**Concord Hospital Concept Proposal & Stage 1- Modification 4 (SSD-9036-Mod-4)  
Request for Additional Information**

I refer to Modification 4 for the Concord Hospital Concept Proposal and Stage 1 (SSD-9036-Mod-4). After careful consideration, the Department is requesting that you provide updated architectural plans that clearly show the proposed design changes.

TITLE
ELEVATION - IPU 1 EAST & IPU 2
WEST

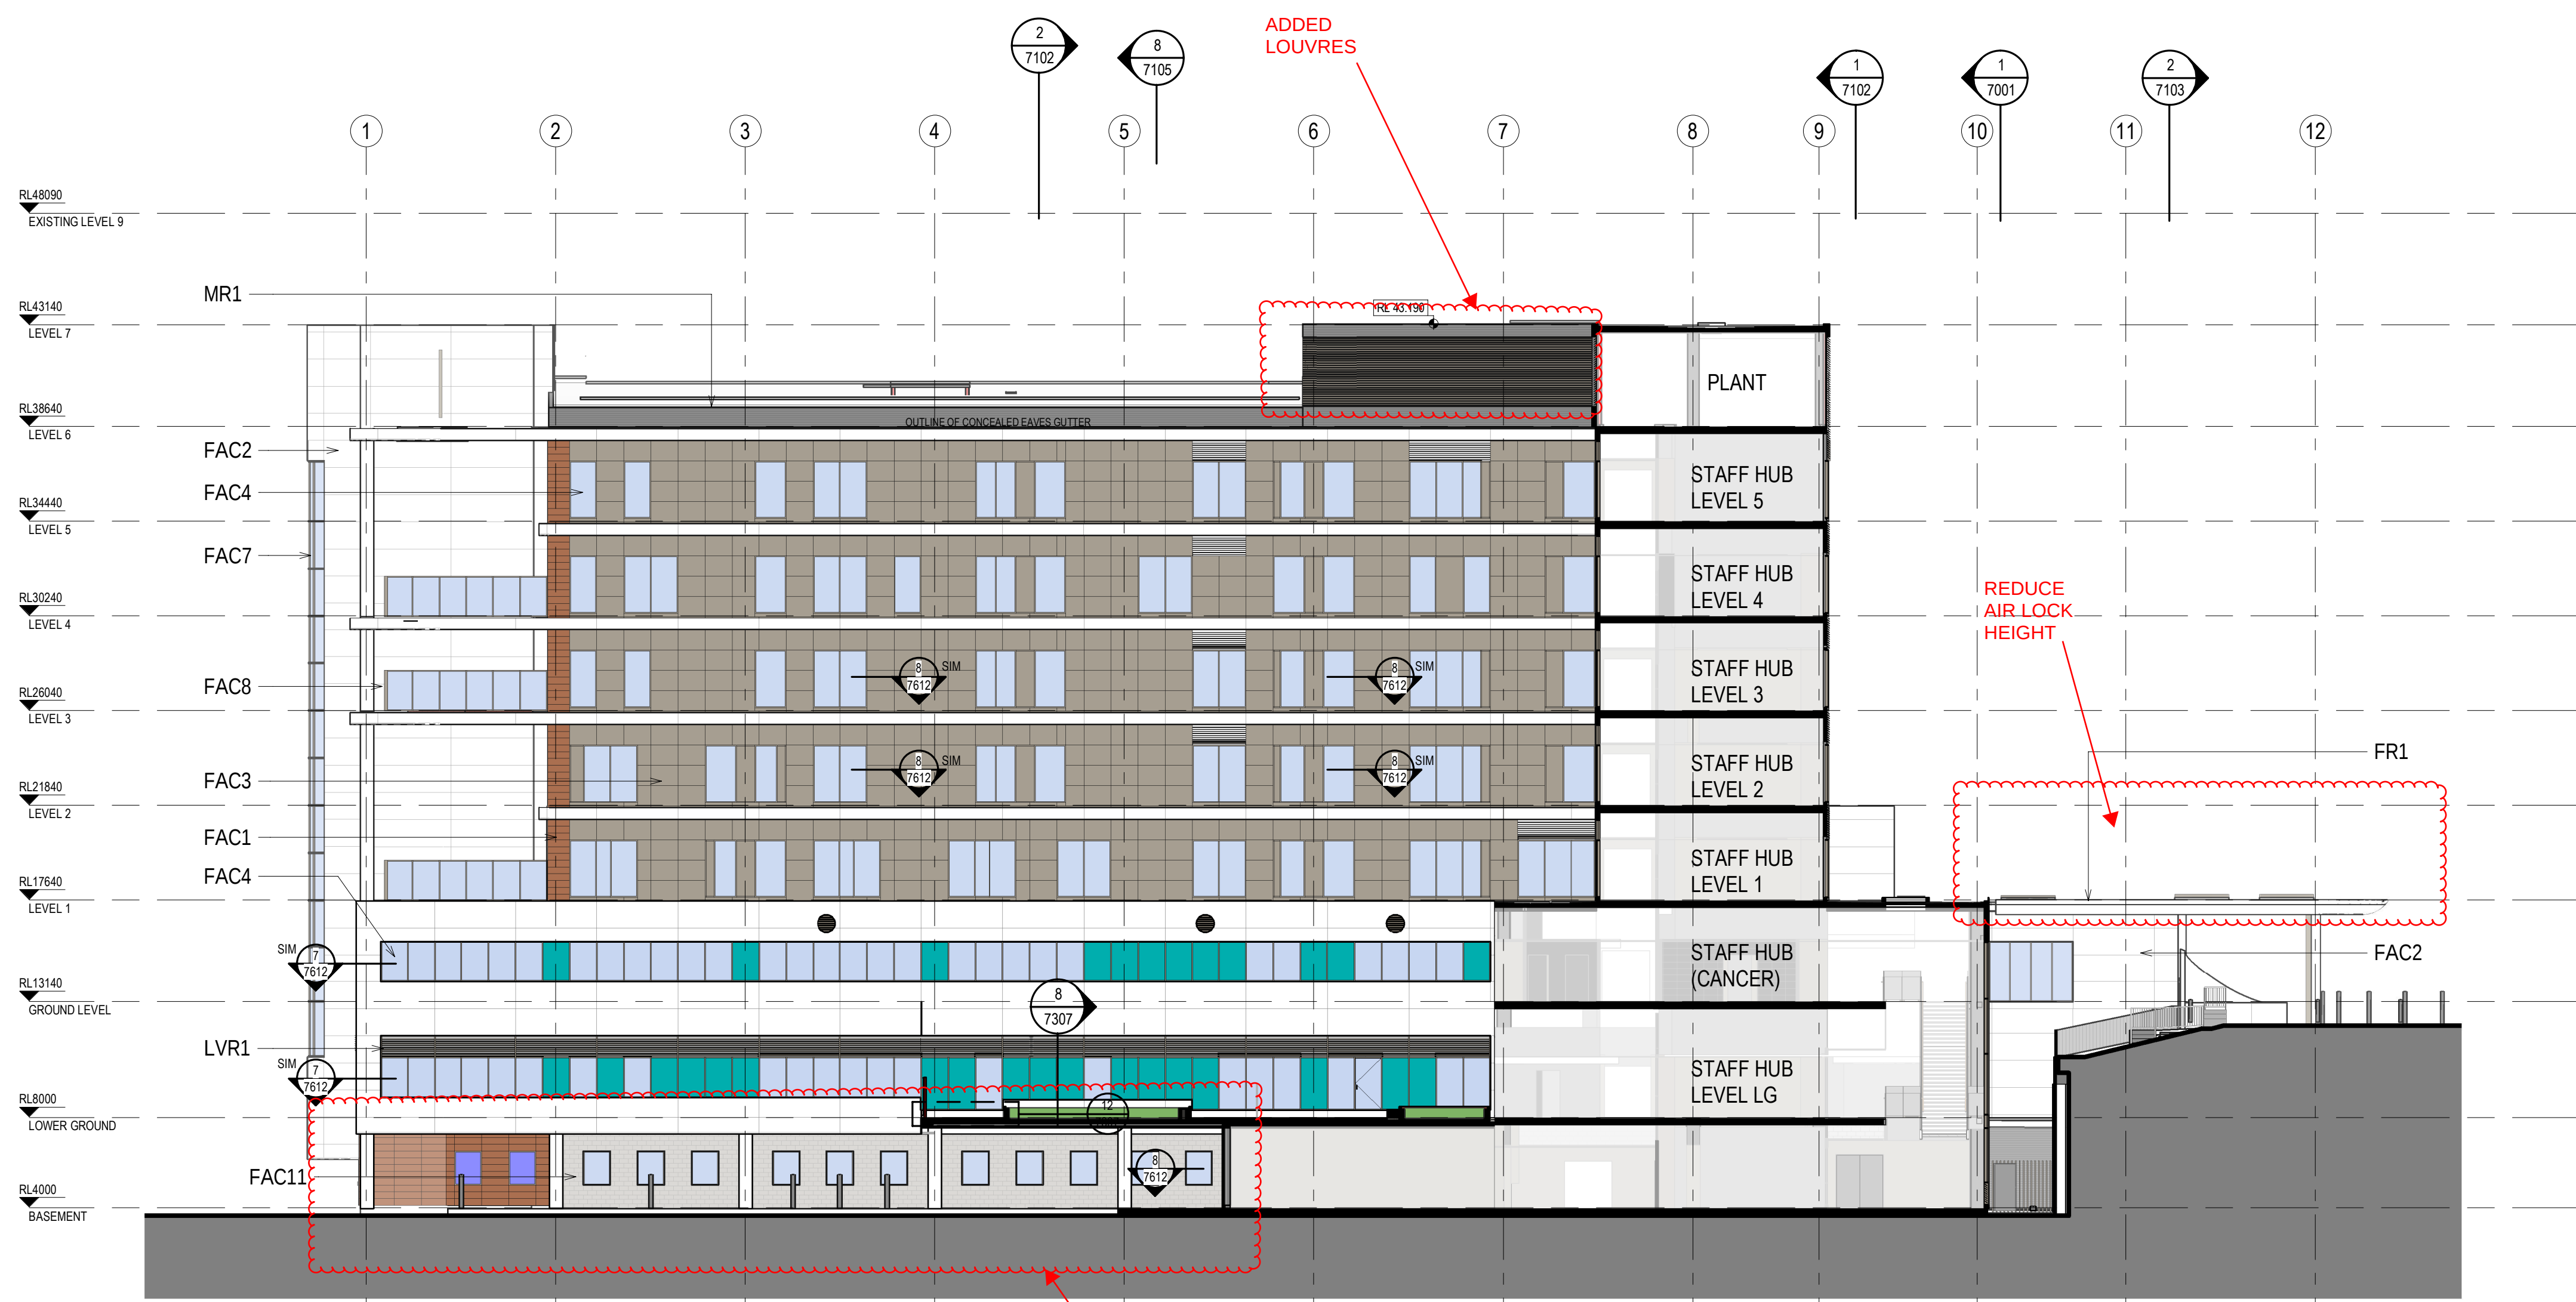
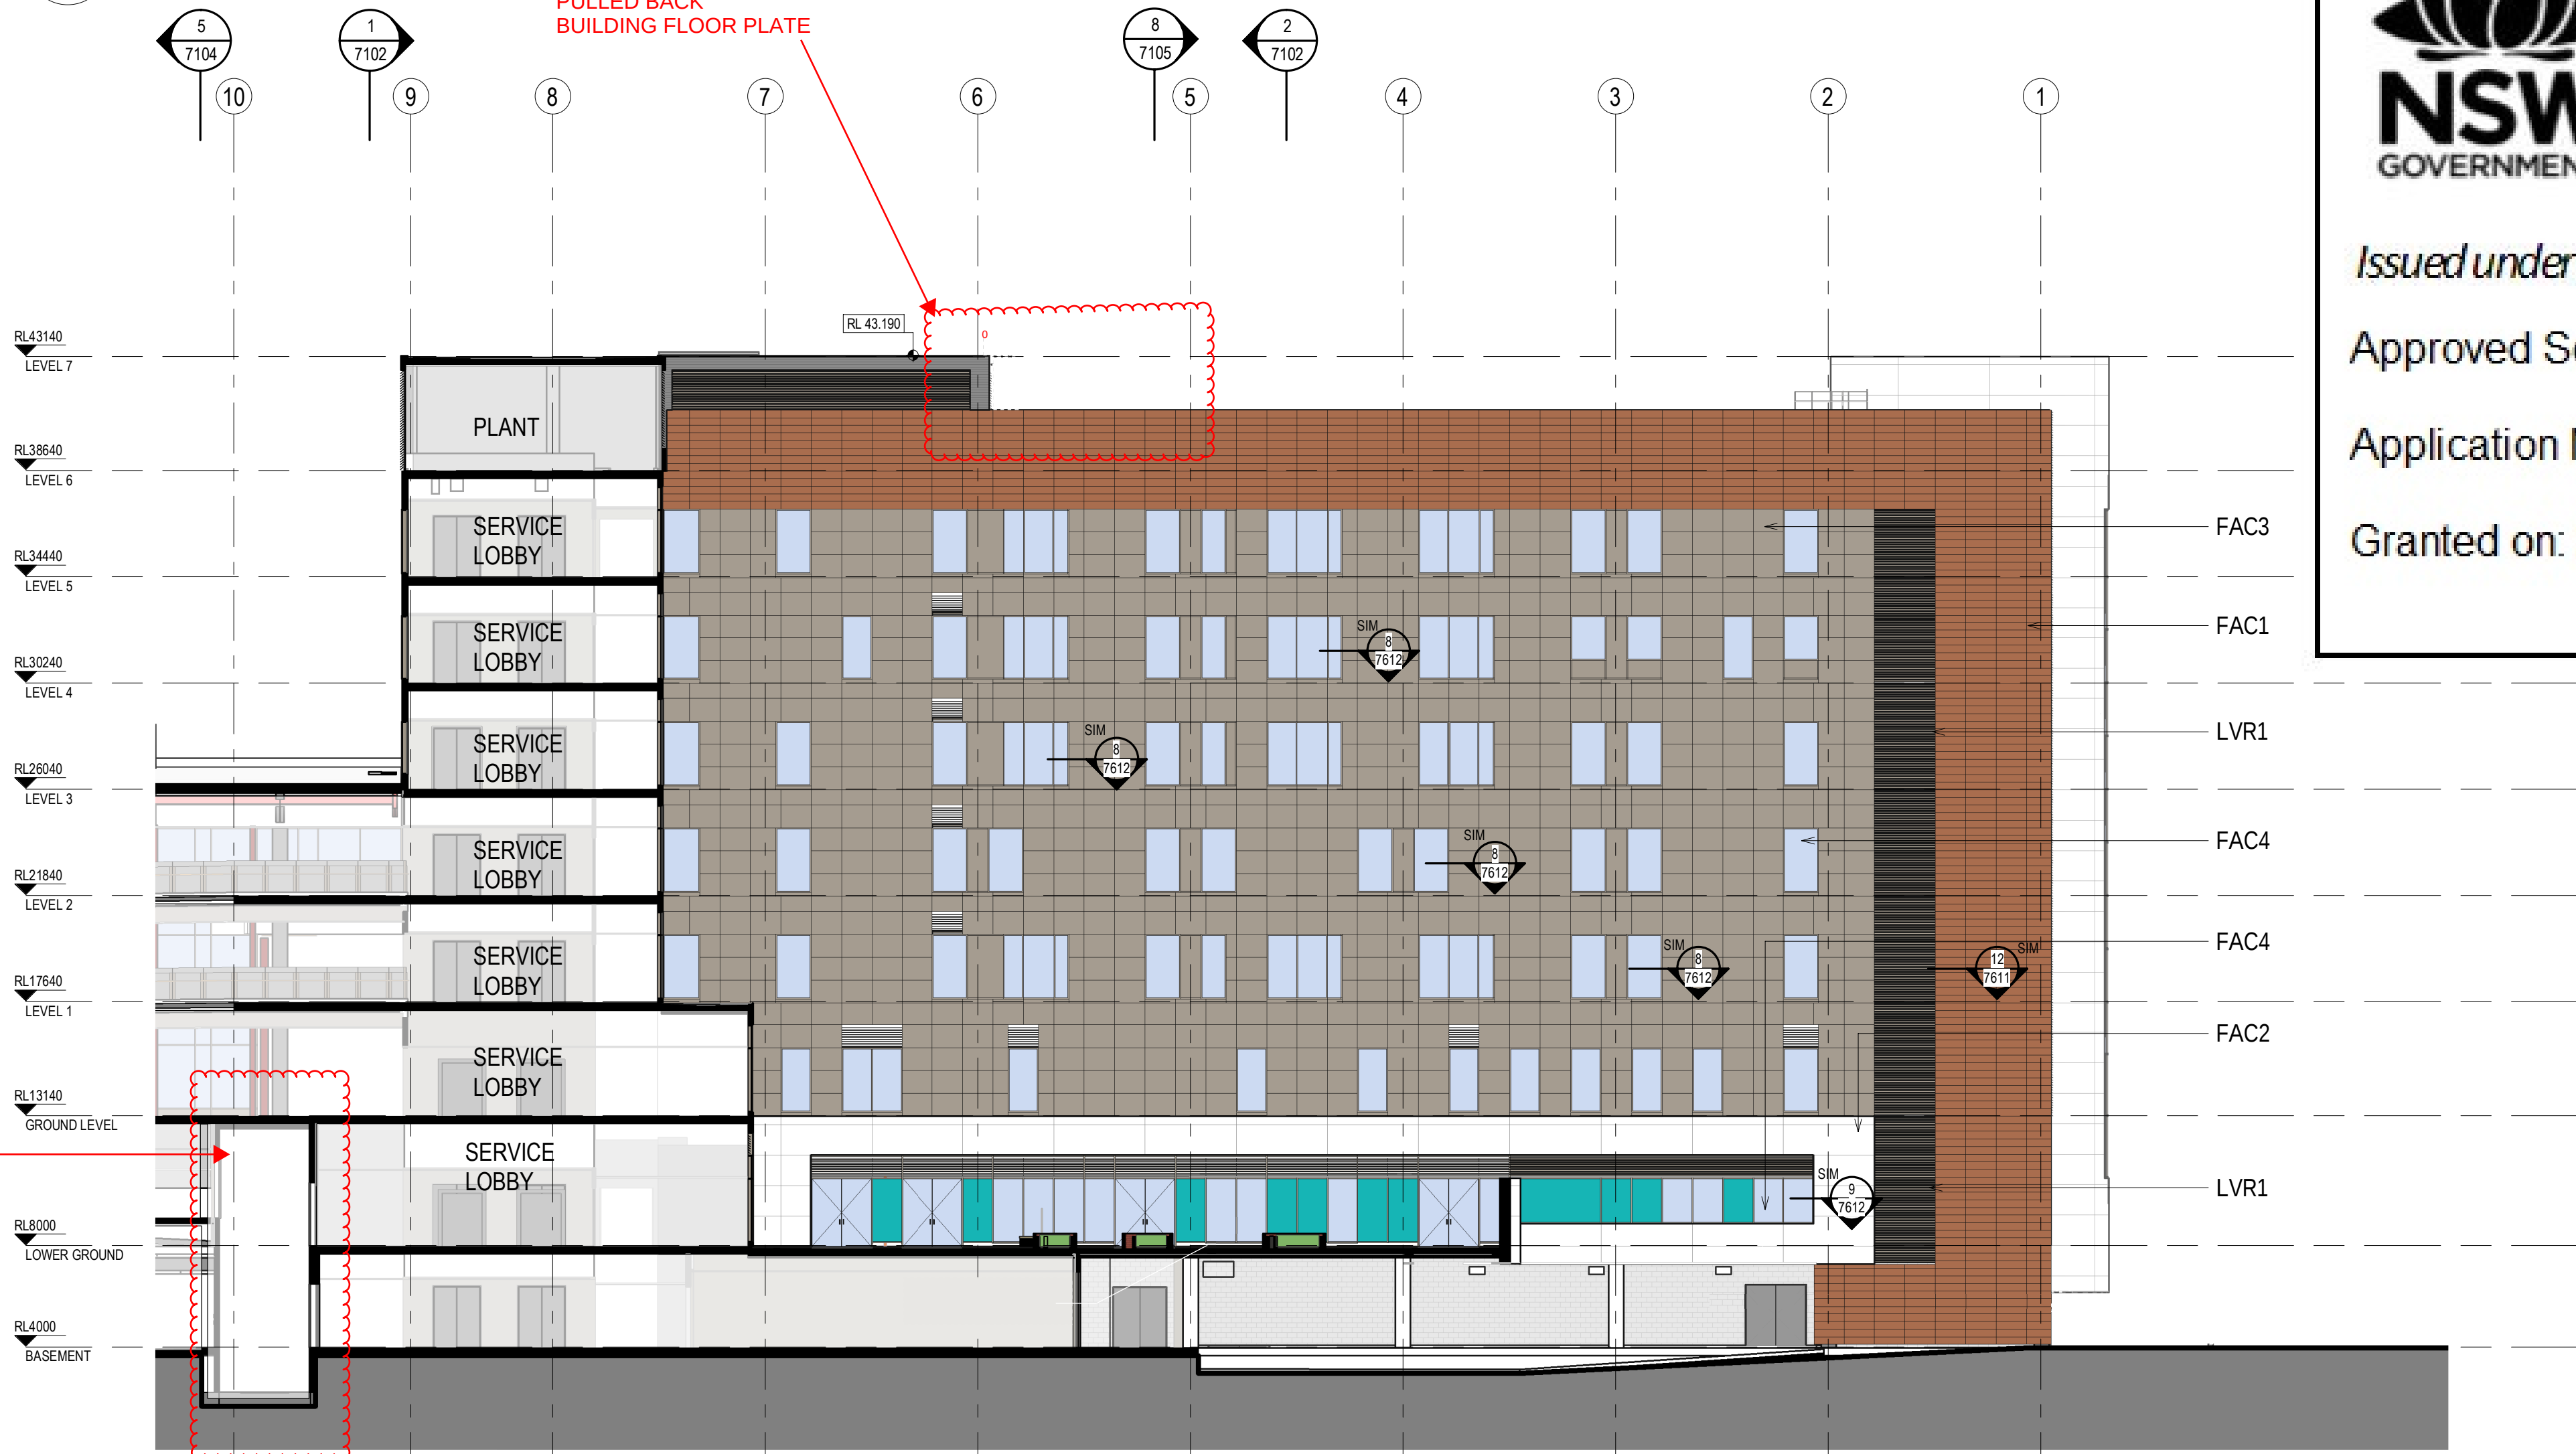
- Elevation North & South.
- Elevation East & West.
- IPU 1 East & IPU 2 West.
